**Consultation Response from KC,
Highways Development Management****2020/93954 Land at, Lingards Road, Slaithwaite, Huddersfield, HD7 5HY****Erection of 57 dwellings and associated works****Date Responded:
05/02/2021****Responding Officer: Mark
Berry****Responding Ref: 1-32-20**

On further review and following a site on 3rd February Highways Development Management have the following additional comments:

Client	Alcuin Homes		
Project	Lingards Road, Slaithwaite		
Title	Site Access GA & Refuse Vehicle Tracking		
Drawn	RD	Date	26.11.14
Scale	1:150 @A1	Checked	JL
		Dr. No.	7364/001
		Rev.	A

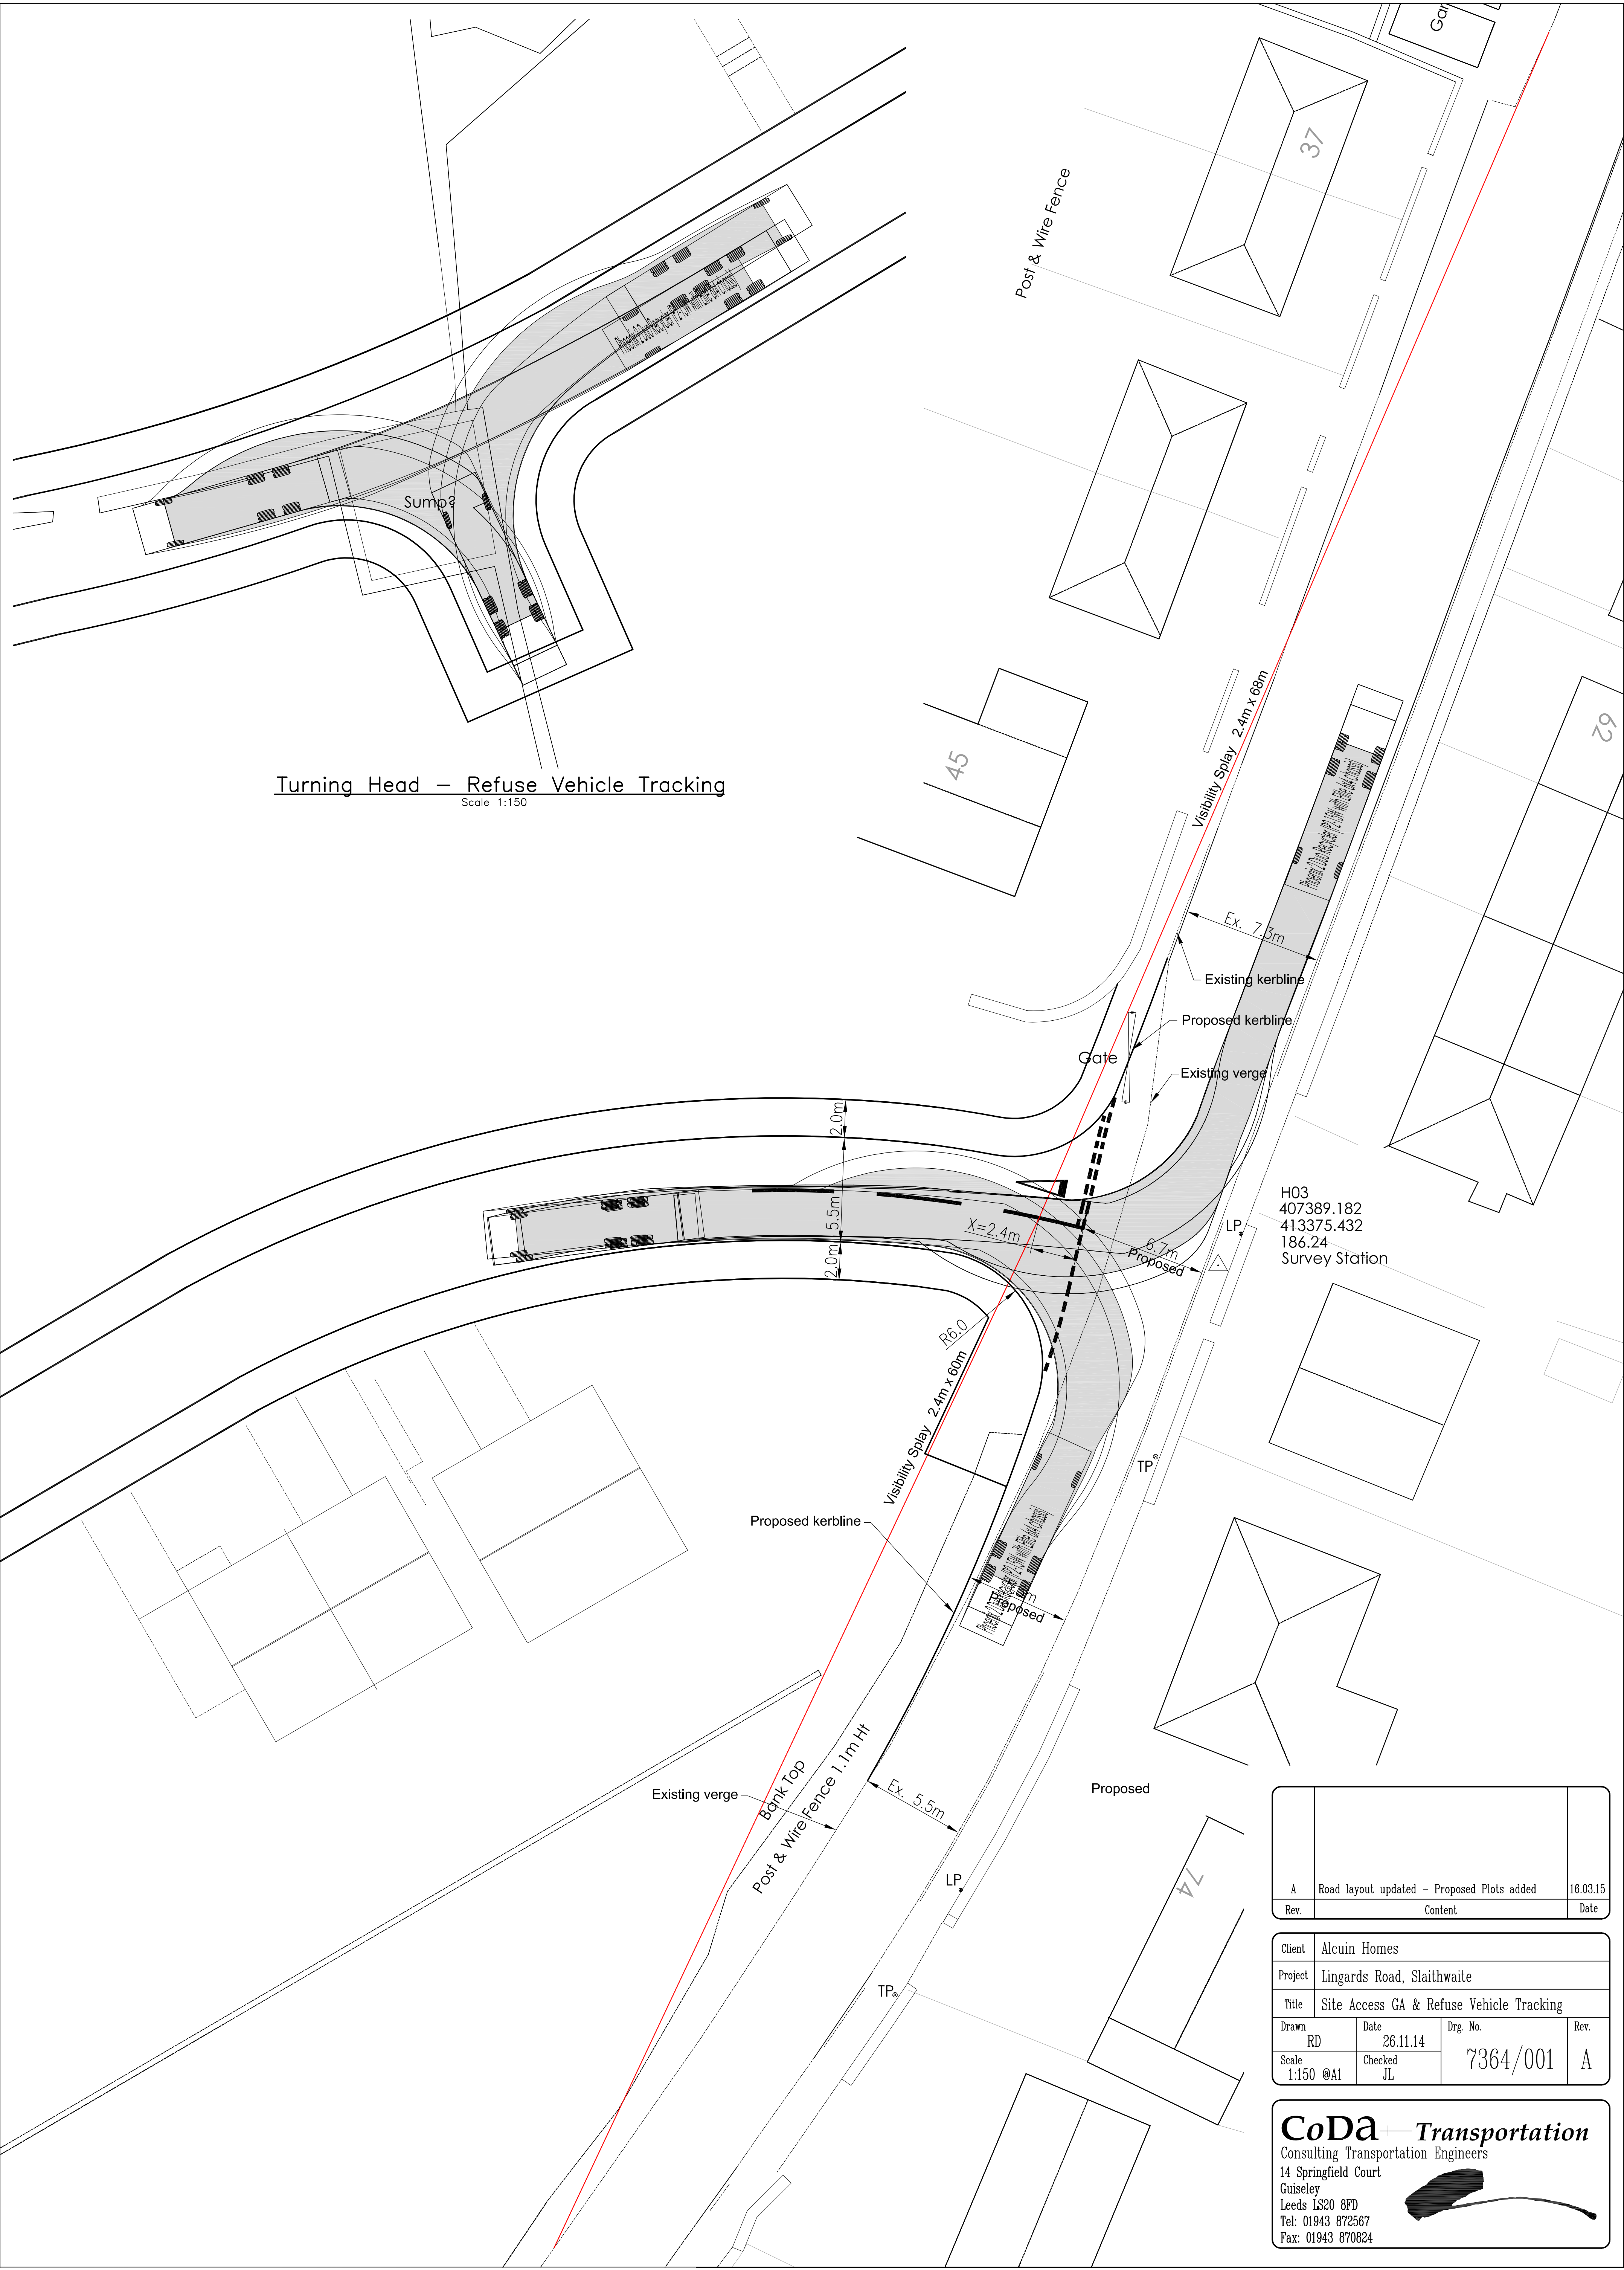
The applicants should be asked to consider the implication of the on-street parking that may occur at this location between the site access and Nields Road, along the site frontage and to the frontage of the Nields Junior and Infant School. In the first instance peak time parking surveys (6am to 9am and 3pm to 6pm) should be undertaken to provide an understanding of the existing problems. Recommendations for appropriate mitigation works possibly in the form of strategically places additional waiting restrictions should also be provided.
